Study Area and Development Footprint

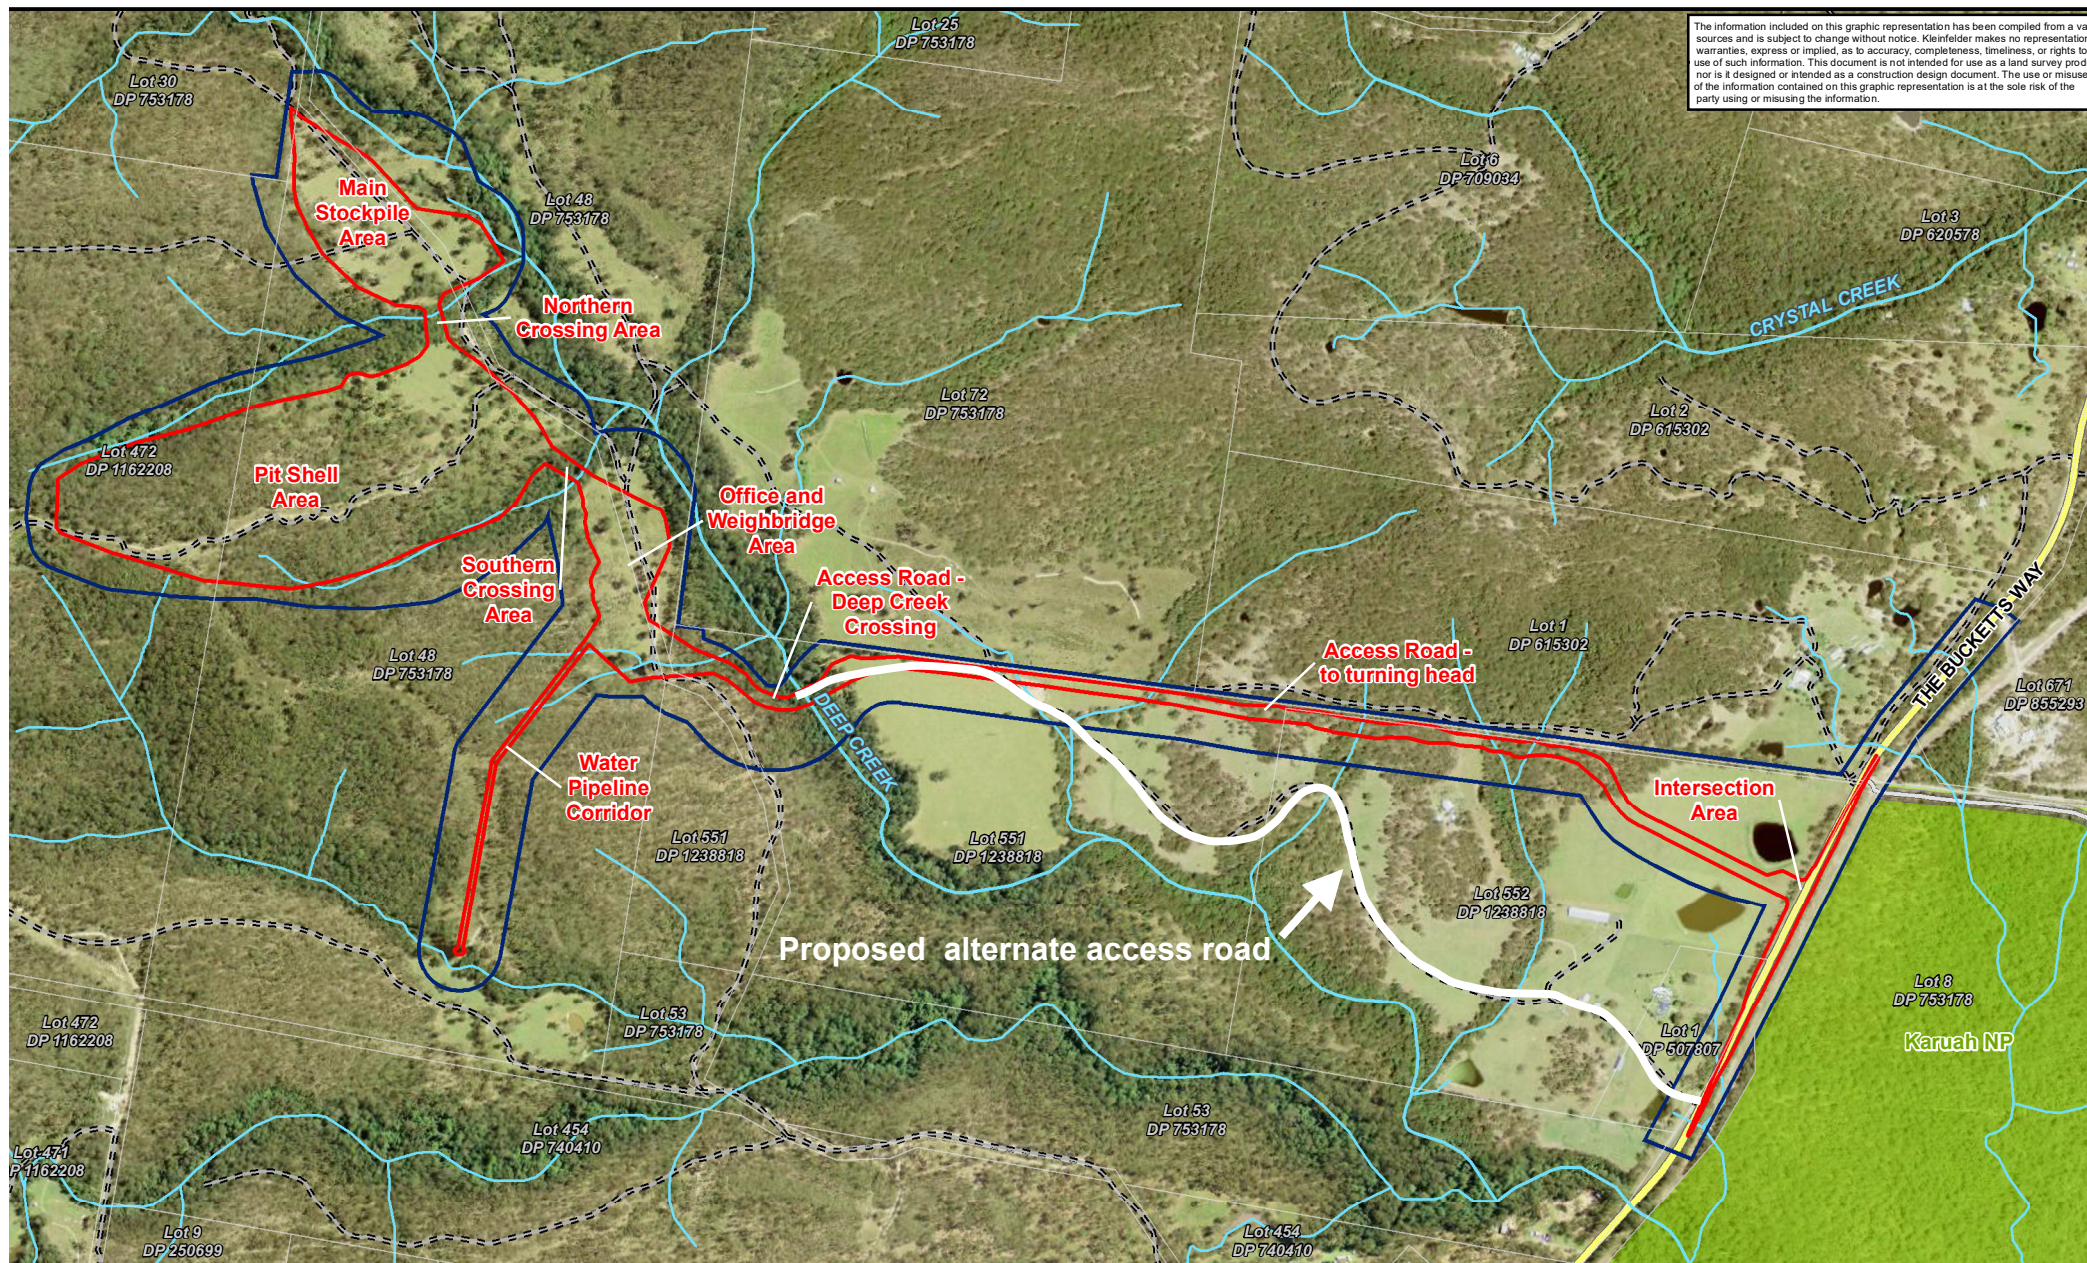
The other alternative is shown in an attachment (extracted from the EIS with the alternate route highlighted in white) and utilises existing gravel sealed tracks through the same 3rd party properties that are allowing the current proposed access road route. This proposed route generally follows a track (marked on the map) through the properties, part of which is presently gravel sealed allowing limited heavy truck use, meeting the EIS proposed route to the west of the boundary of DP 1/615302. Anecdotal objection to this alternative was that there will be insufficient "acceleration lane length" on The Bucketts Way before the Deep Creek bridge going south. The obvious solution being to widen Deep Creek bridge - a significant expense, but if the proposers do not wish to use the public road already available to them, and use a 3rd party property for access, any additional cost would be an outcome of that decision. This alternate would alleviate the diesel related health concerns of my neighbour at DP 1/615302, and also move the access road further from my property at DP 2/615302 helping to reduce any transport noise and dust concerns.

It should be noted that the EIS map (the attachment) is not correct - the boundary for DP 1/507807 was moved further north as to that shown (ref sub certificate number SC 2021/0050, registered 30/9/2021). This boundary change would alleviate the above alternate route having to cross DP 1/507807. The owners of DP 552/1238818 and DP 551/1238818 have already made arrangements with the quarry proposers to allow the access road to be established across their properties. The alternative shown in the attachment simply moves the route such that it alleviates the issues with the owners of DP 1/15302 albeit requiring work on Deep Creek Bridge.
